KIRKLEES METROPOLITAN COUNCIL INVESTMENT & REGENERATION SERVICE

DELEGATED DECISION TO DETERMINE APPLICATIONS FOR NON-MATERIAL AMENDMENTS

Reference No: **2024/NM/92974/W**

Site Address: Greenhead College, Greenhead Road, Huddersfield,
HD1 4ES

Dwg. No.	NE8659- OOB- ZZ- 00- DR- L- 0001	Scale	1 : 500 @ A2
Revision	P37	Date	February 2021

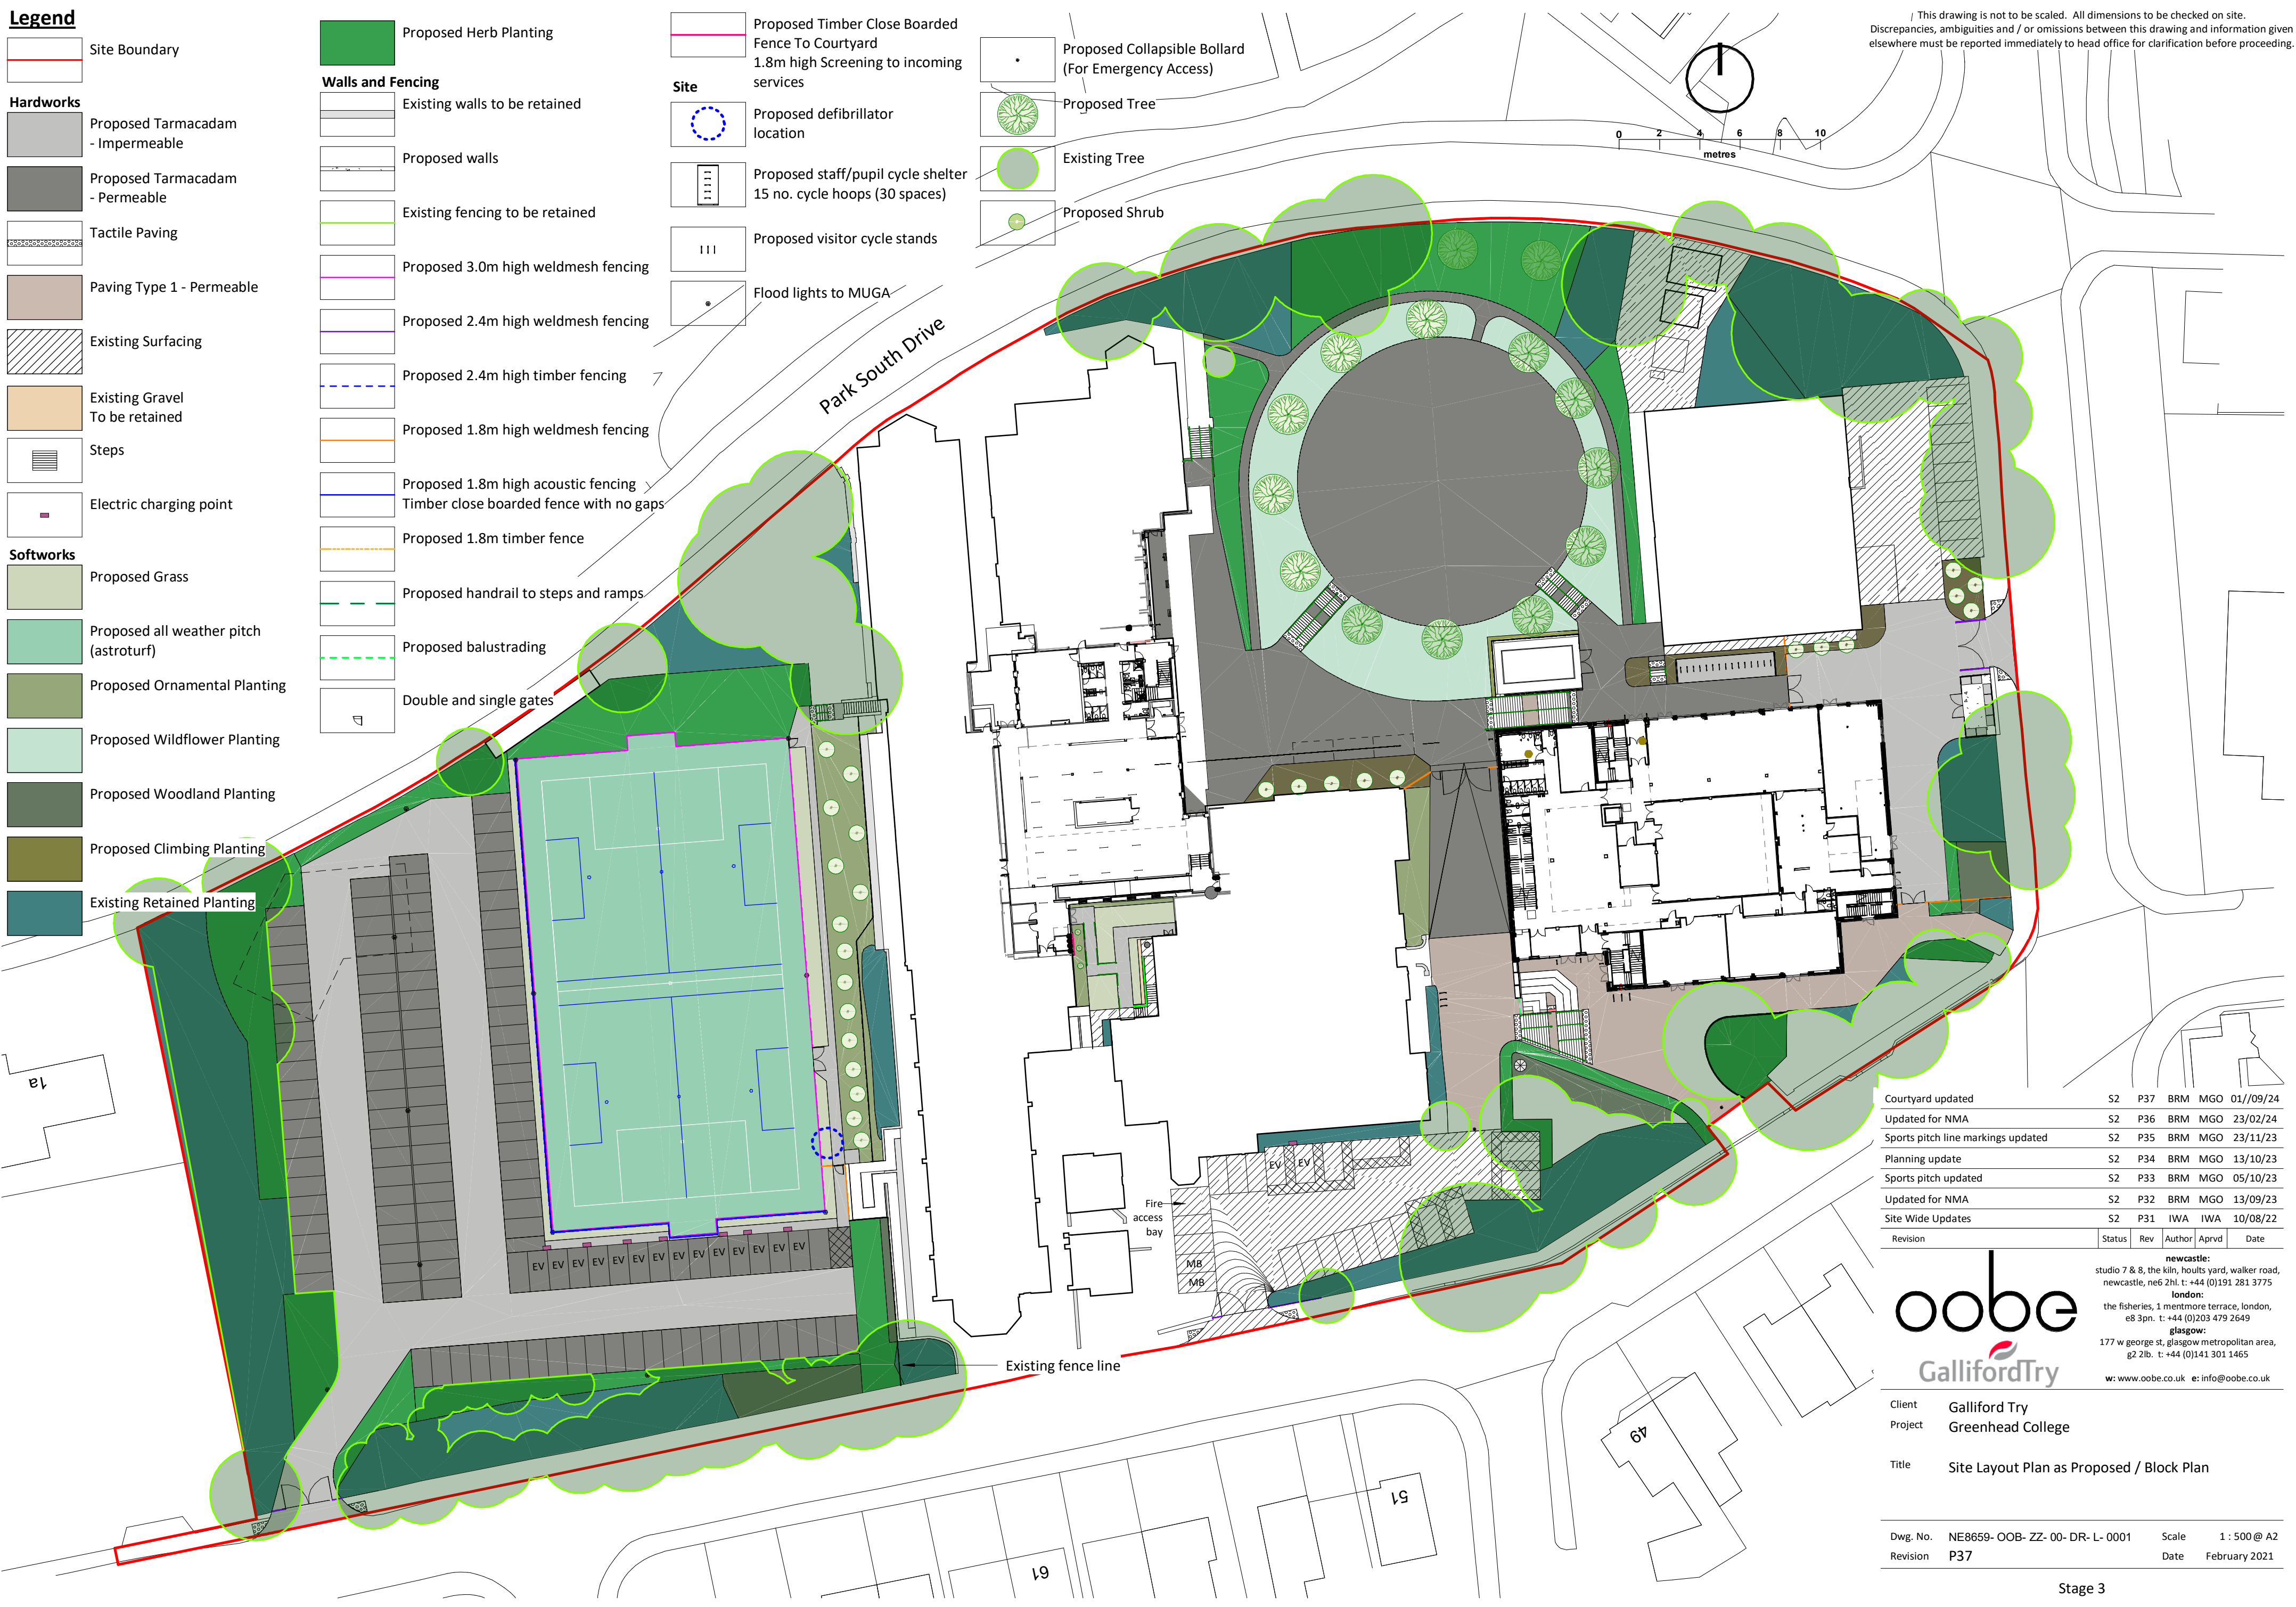
- *The courtyard landscape proposals have changed due to the College library fire exit access design and level changes that were not originally understood. The existing landscape design has 30sqm of ornamental planting with three feature plants. These will be reprovided in an amended design as follows:*

- *Compliant route through the courtyard with handrails where appropriate;*
 - *Timber close board fence to screen incoming services; and*
 - *Ornamental planting updated to suit latest design with feature shrubs and areas seeded with grass.*
